ATLASSIAN OFFICE AND HOTEL DEVELOPMENT SSD-10405 MOD 1 - RESPONSE TO REQUEST FOR ADDITIONAL INFIRMATION

The RFI is in relation to a Section 4.55(1A) modification application (MOD 1) for the approved State significant development SSD-10405 which approved an office and hotel accommodation development at 8-10 Lee Street, Haymarket.

DPE have identified a number of additional minor changes shown on the architectural plans submitted alongside MOD 1 which were not approved in the plans as part of SSD-10405. DPE has requested clarification and justification for any additional design changes sought.

DOCUMENT NUMBER
DA-09B-B01-00

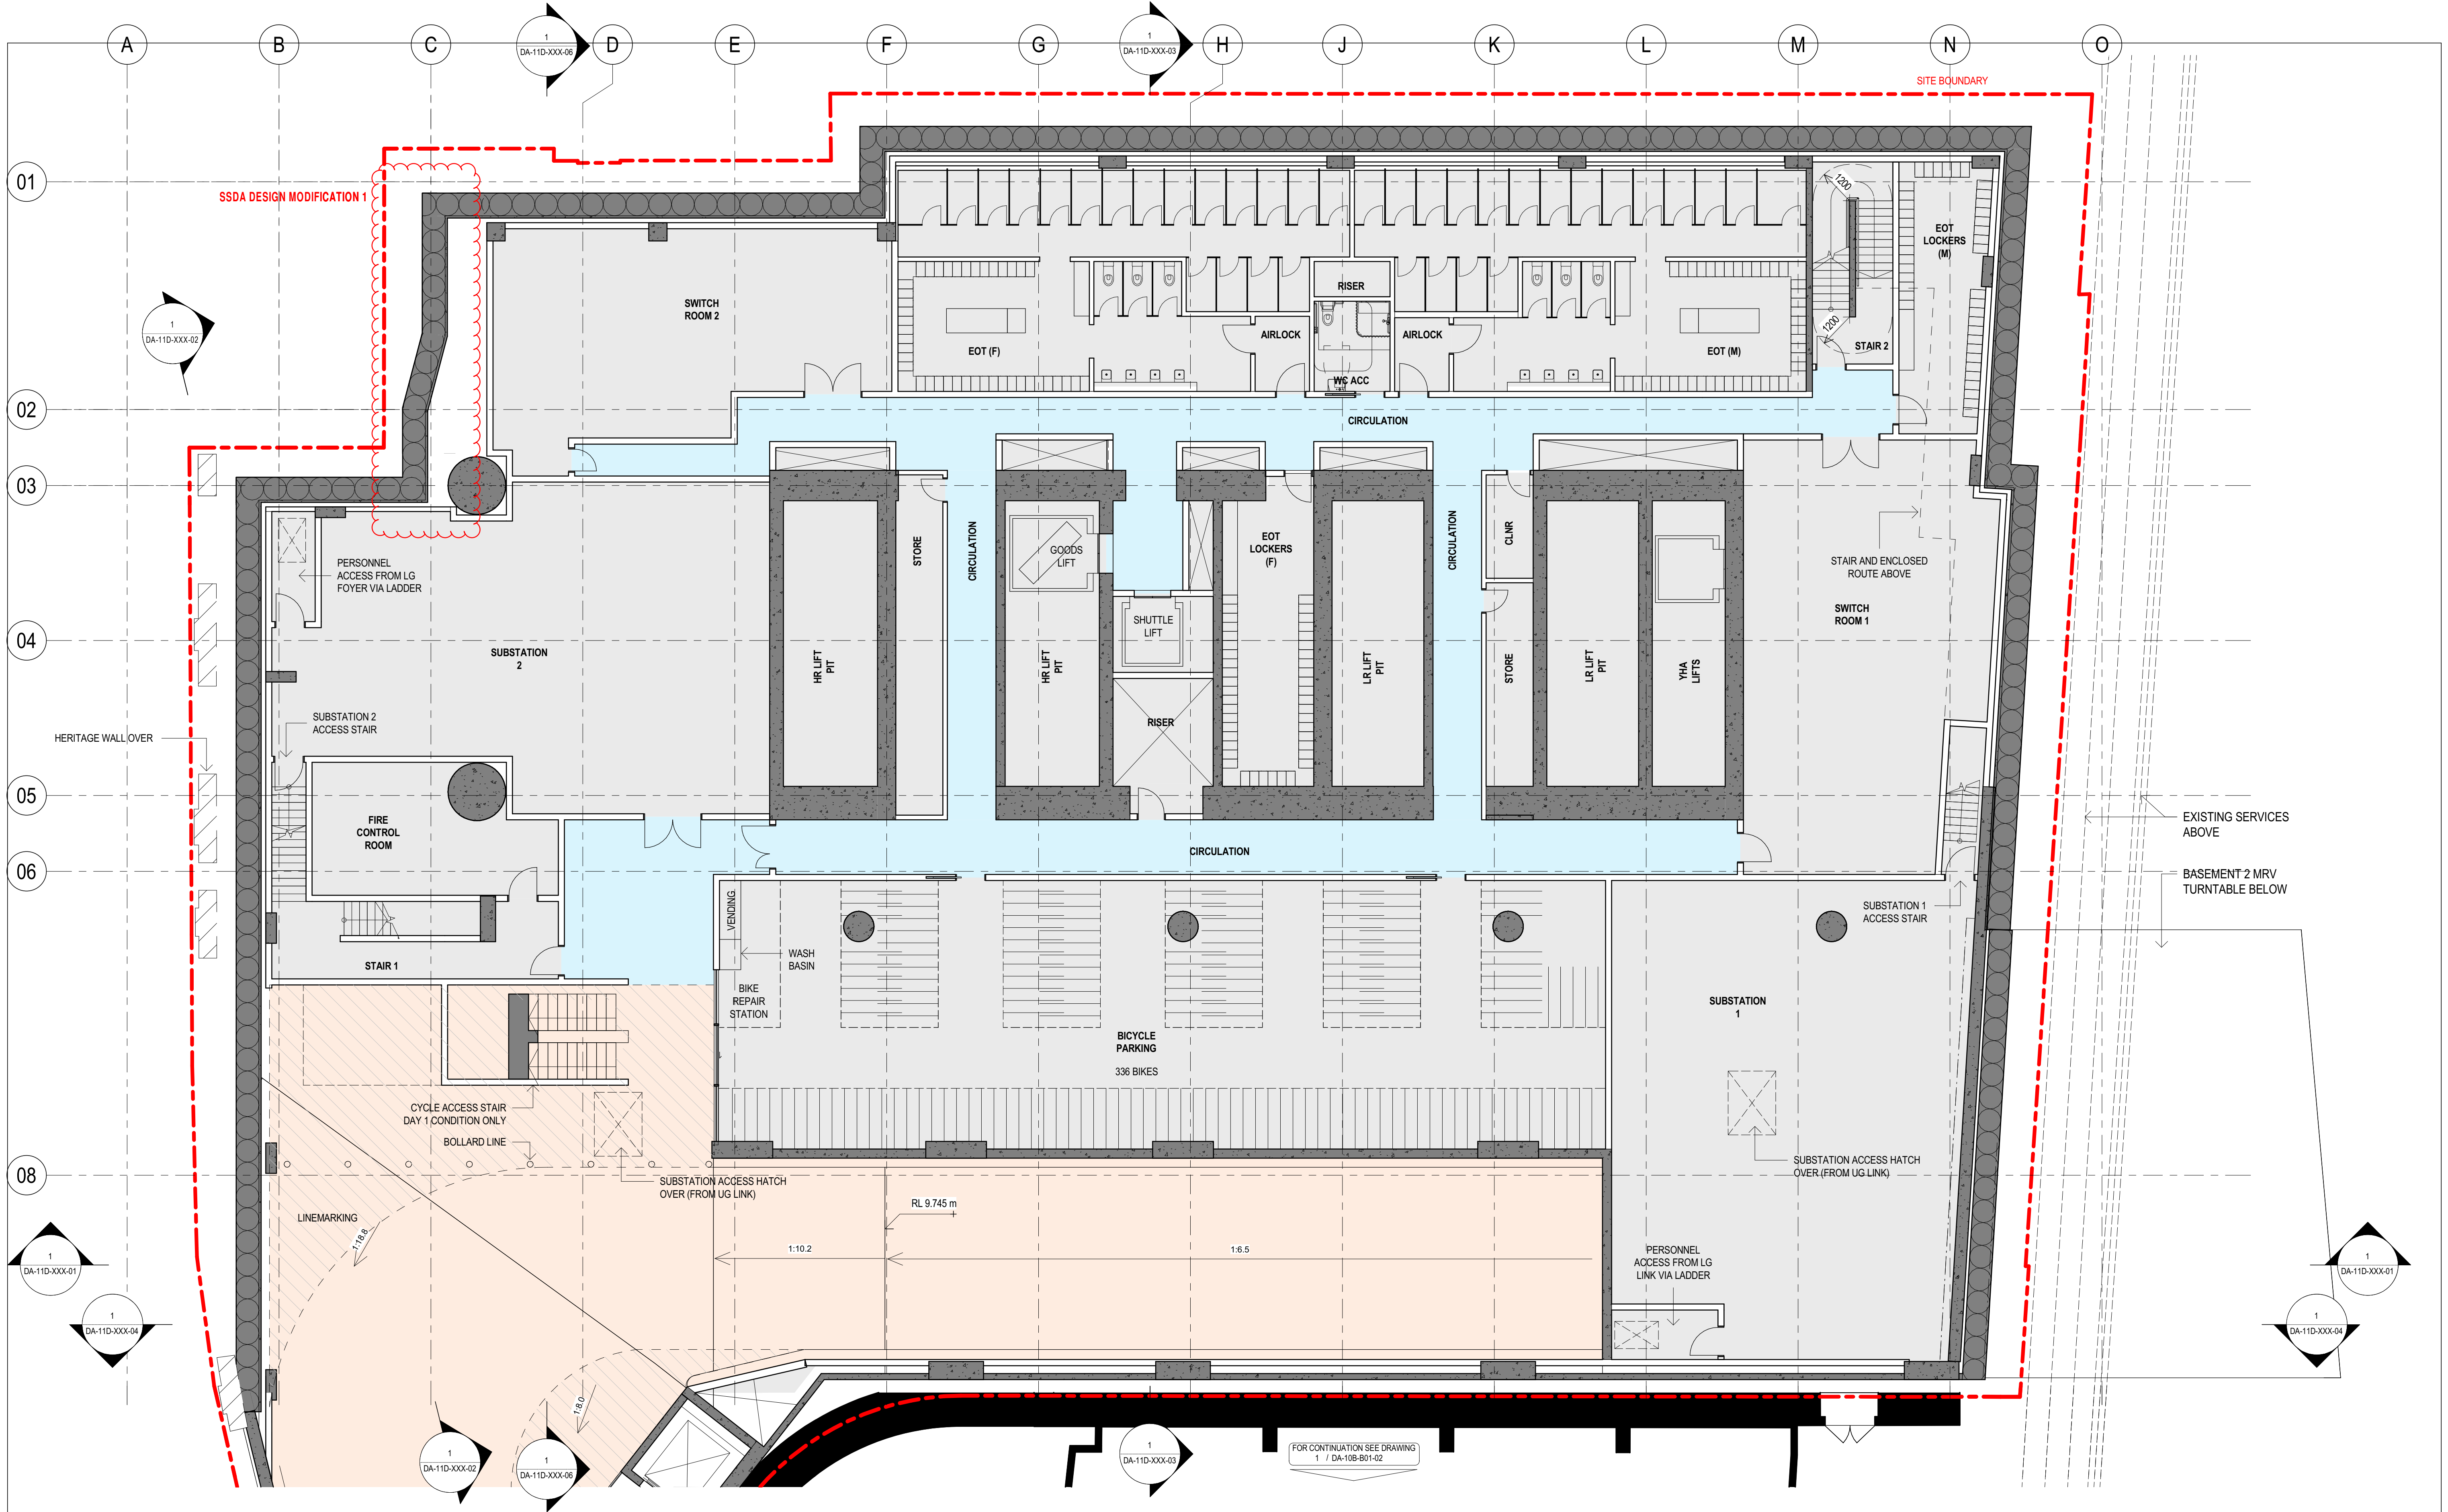
1. DA-09B-B01-00 rev 8 / Updated survey information regarding subterranean elements comprising the neighbouring building (Adina Hotel)
2. DA-09B-B01-00 rev 8 / Minor development on internal planning to toilet areas inside the End of Trip Facility, which are superseded by changes addressed in the MOD 2 Submission recently lodged.
3. DA-10B-B01-01 rev 8 / identical to the above.
4. DA-10B-B01-01 rev 8 / Graphical error on the drawing showing an incorrect overlay of Structure, which is superseded by changes addressed in the MOD 2 Submission recently lodged.

Update plans have been prepared by SHoP and BVN resolving issues 2-4 above. It is noted that the updated survey information has been left on the plans as this is part of a neighbouring building and does not constitute any change sought under MOD 1.
